Immingham Green Energy Terminal

10.8 Proposed Further Change Application Report

June 2024

Document Reference: TR030008/EXAM/10.8

Site Boundary & Works Plans Changes between DCO Application (September 2023) & Change Application (March 2024) Key Plan

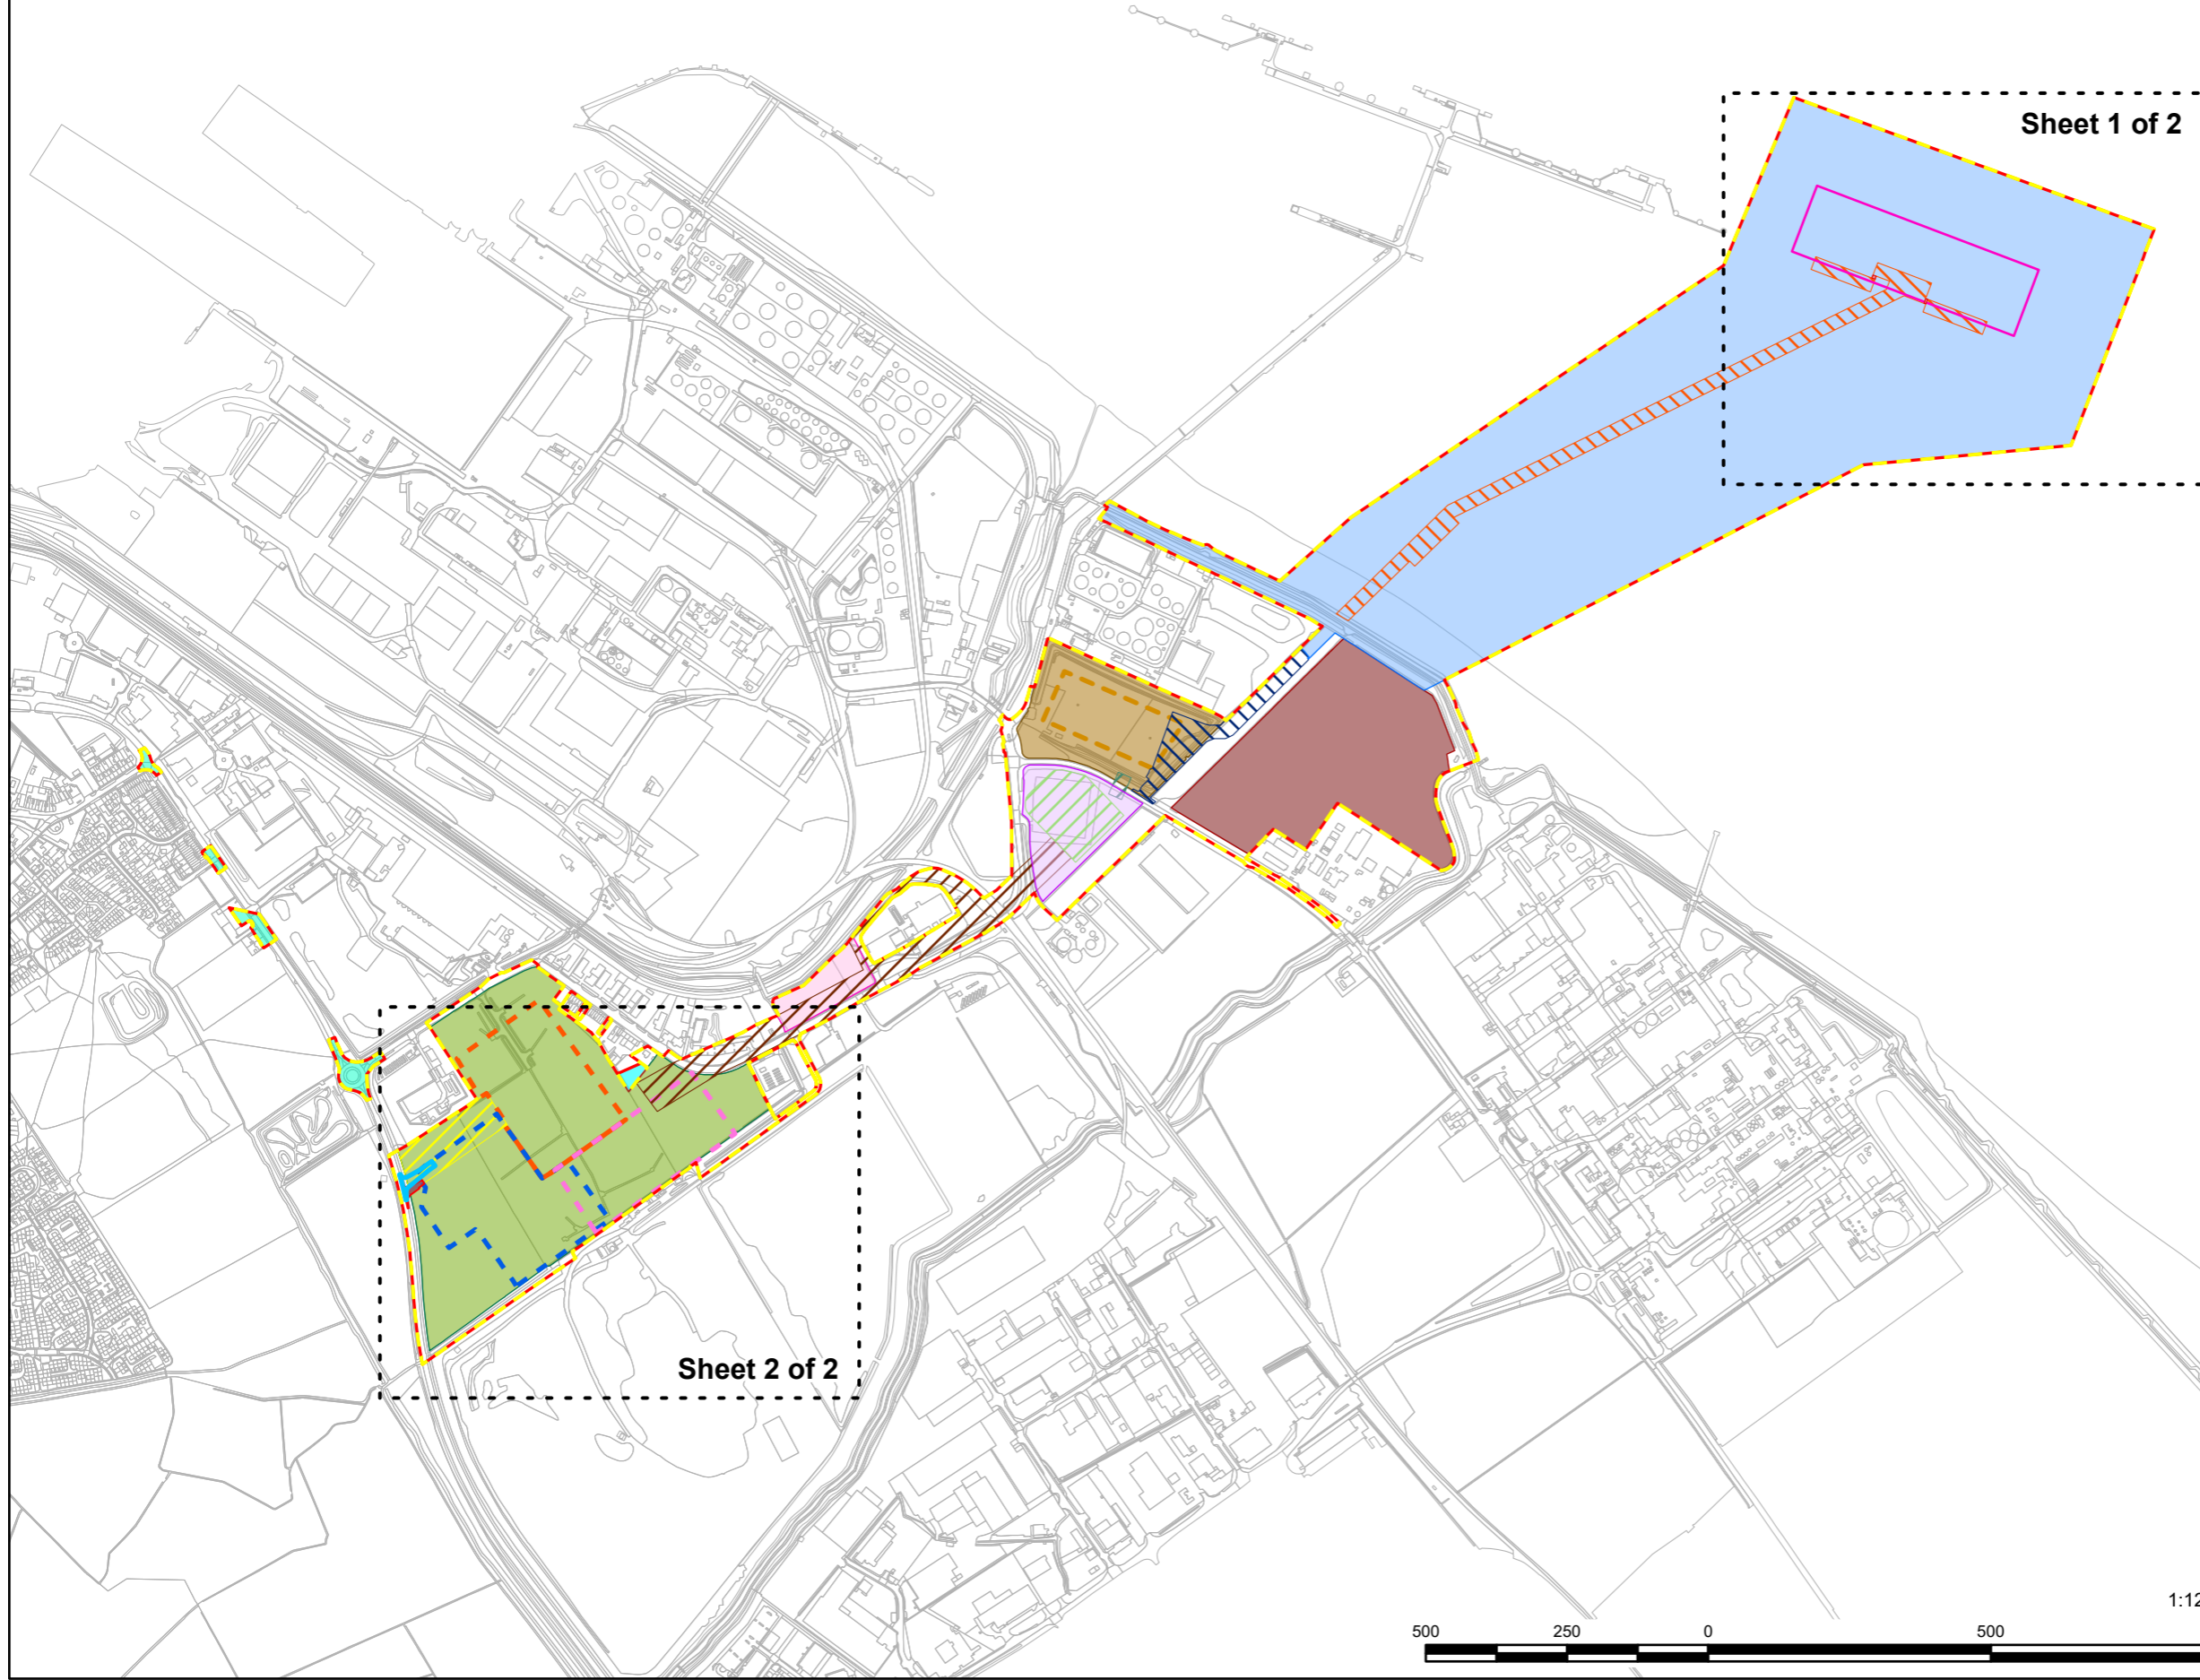
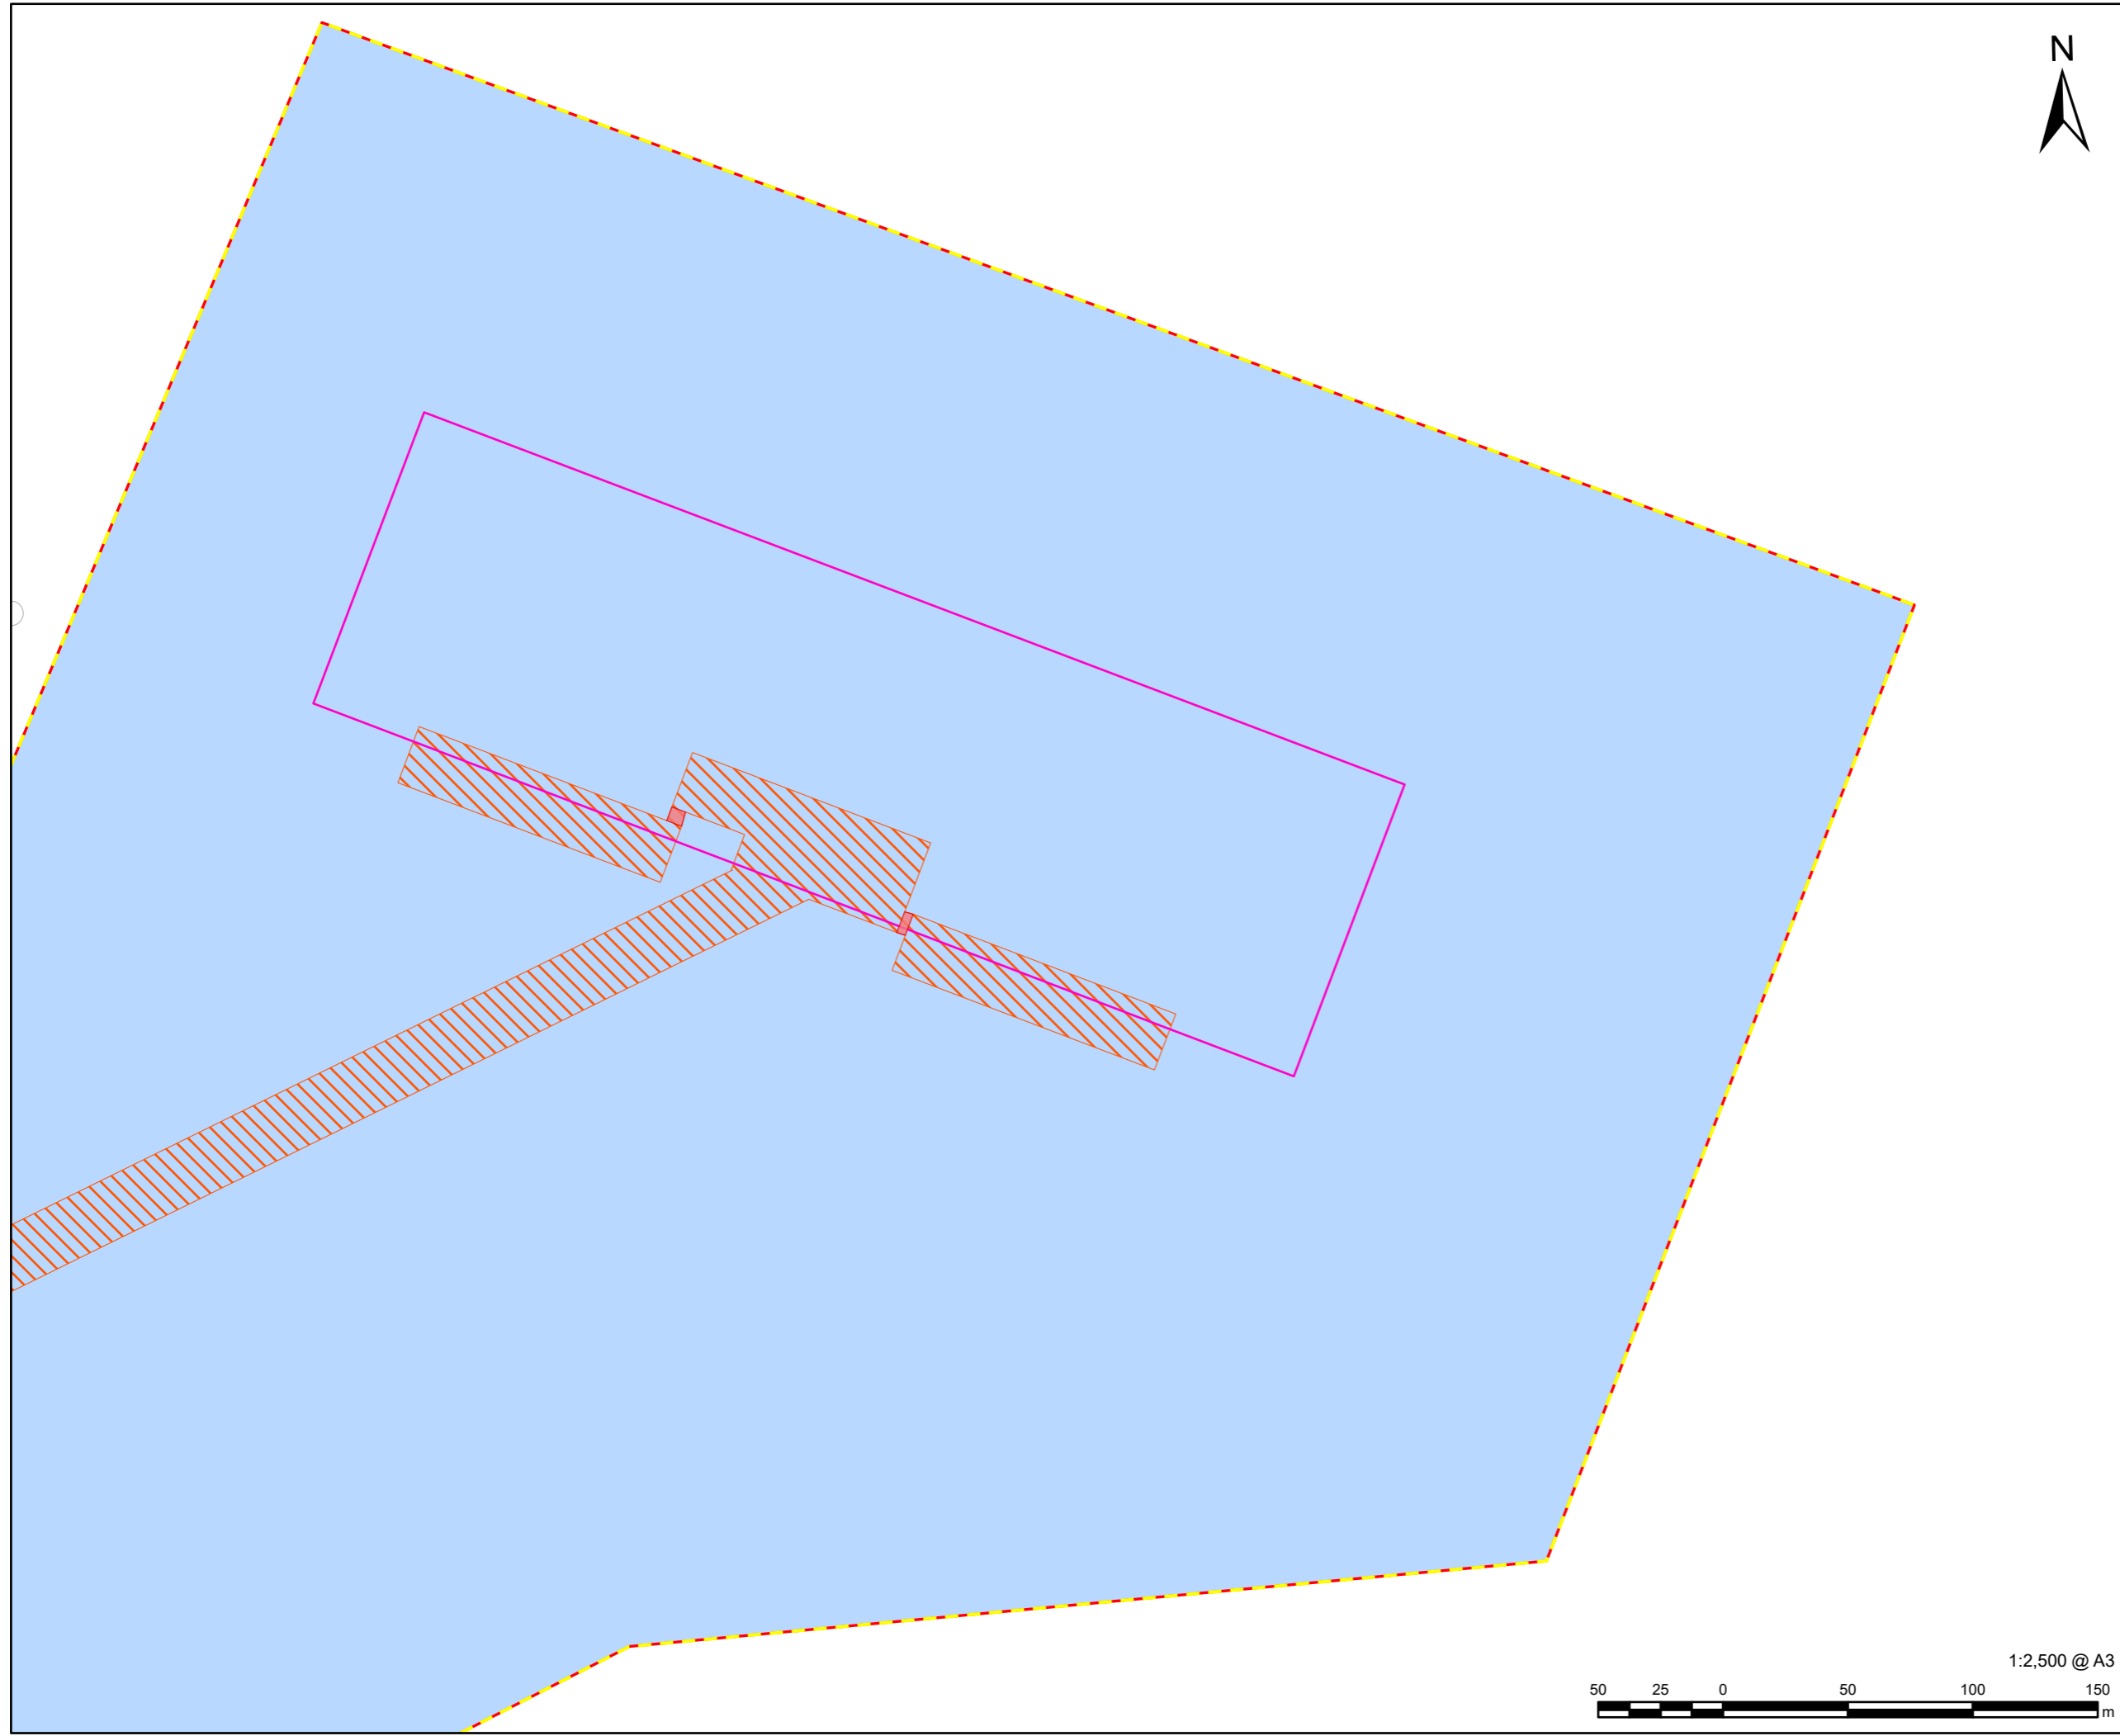
2.6.1 Proposed Change 7 consists of a beneficial reduction in the area of Work No. 9 (2.64 ha). Work No. 9 is proposed to be used for temporary construction purposes and temporary possession powers are sought in relation to Work No. 9 during the construction period.

2.6.2 The reduction in Work No. 9 is proposed following engagement with two parties. First, the Environment Agency has indicated that there is a small area of Work No. 9 close to the North Beck Drain which is liable to flood and so should not be used for construction purposes. Additionally, during engagement with the owner of part of Work No. 9 on the terms of an agreement for lease of that land, the owner expressed a desire to retain possession of a particular part of the land for its own purposes. After further review of the land required for construction purposes based on latest information, the Applicant has concluded that these requests can be accommodated and have the benefit of enabling the reduction of the area required for Work No. 9, and also the Order limits, as well as reducing the area subject to powers of temporary possession in connection with the Project.

2.6.3 **Appendix 1** illustrates the location of the proposed change and **Appendix 2** illustrates the reduction in the Order limits as a result of the reduction in the area of Work No. 9.
